**WEST SUSSEX COUNTY COUNCIL
STRATEGIC PLANNING CONSULTATION**

DATE: 21st October 2016

SUBJECT: LU/234/16/RES - Application for reserved matters relating to access, appearance, landscaping, layout and scale of the previously approved LU/63/11/. This application affects a Public Right of Way.

LOCATION: Fitzalan Link Road, Worthing Rd (A259), East Street, Littlehampton, West Sussex.

| drawing number | PHF-MB-S278-GF-DR-D-PROW-01 | rev.     |             |            |    |

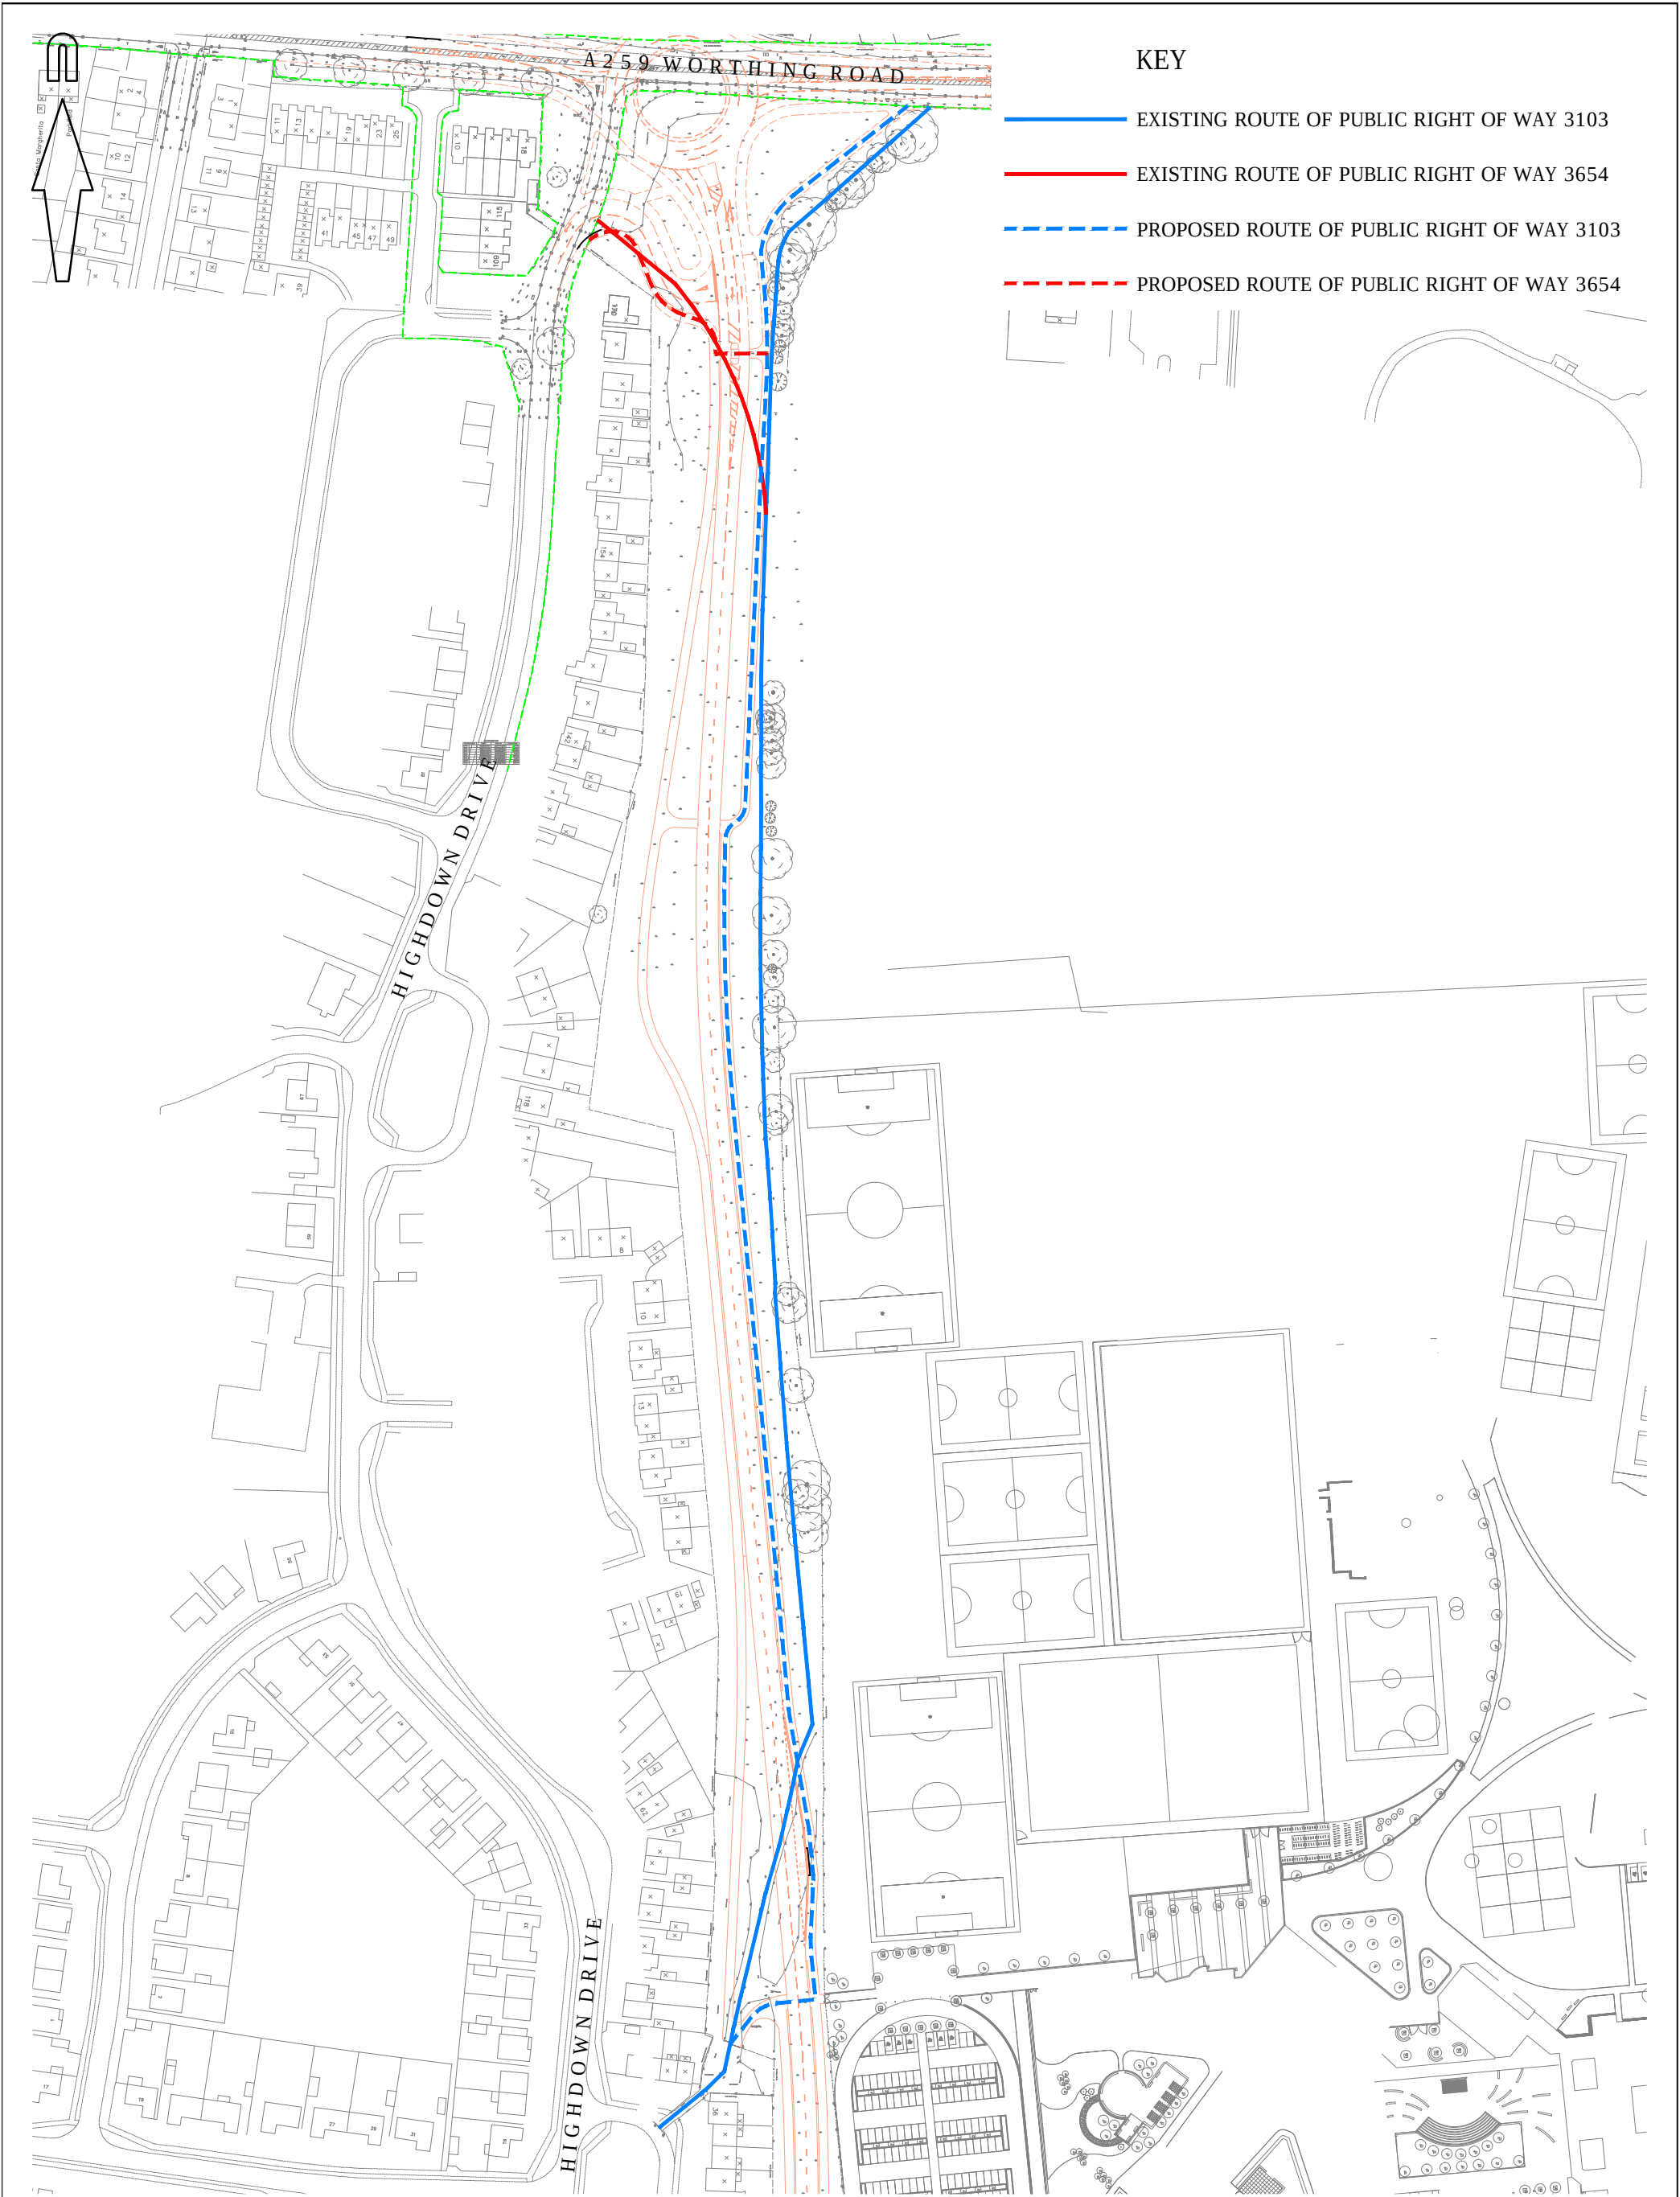
6. Confirmation that all PRow have been considered in-line with County advice. PRow have been considered as part of this REM application. Drawing PHF-MB-S278-GF-DR-D-PROW-01 (produced by Mayer Brown Consulting Engineers on behalf of the applicant) shows the proposed routes and alterations thereto. However, when further changes have been made and Safety Audit responses and recommendations received, the routes will need to be reviewed again to ensure route appropriateness and safety. Clearly, a diversion will be required for both the footpaths affected by this proposal, under S.257 of the TCPA. Particular attention must be given to ensure that there are safe crossing points at each necessary point where the routes will be crossing carriageway.

A potential issue could be the closure of these paths whilst the works are taking place because if a route is closed it must be reopened on its original route before any diversion comes into being. This has been the case for a couple of other locations that PRow team has commented on in the past. With regard to this and following up on the point of a temporary closure (TTRO) for works to commence but before a formal diversion process is complete. It is practice not to grant a TTRO unless the line of a highway so closed is the line that will be available upon lifting of the Order. As such, it is recommended that formal diversion is first completed before a TTRO is applied for and, likely, granted. Presumably diversion will be effected under Town & Country Planning Act 1990 S257, where the Local Planning Authority would ordinarily act as Order Making Authority; and the legal test should be simply satisfied, i.e. diversion necessary to enable development to take place.

Another consideration or assumption to make with the above is the intention to retain the future route as a PRow status. If the future route is to become S38 adopted perhaps it is possible to do things in a different way, e.g. once a binding commitment (including timeframe) is given to WSCC for the future route then, perhaps, Legal Services may consider that enough to begin a TTRO process. If the future path is provided to an adoptable standard WSCC would be seeking for it to be added to the gazetteer in any event. For avoidance of doubt, PRow team is not able to maintain routes to that standard. As such, although retaining a legal line of a PRow, any maintenance would then fall to the Area Highways office.
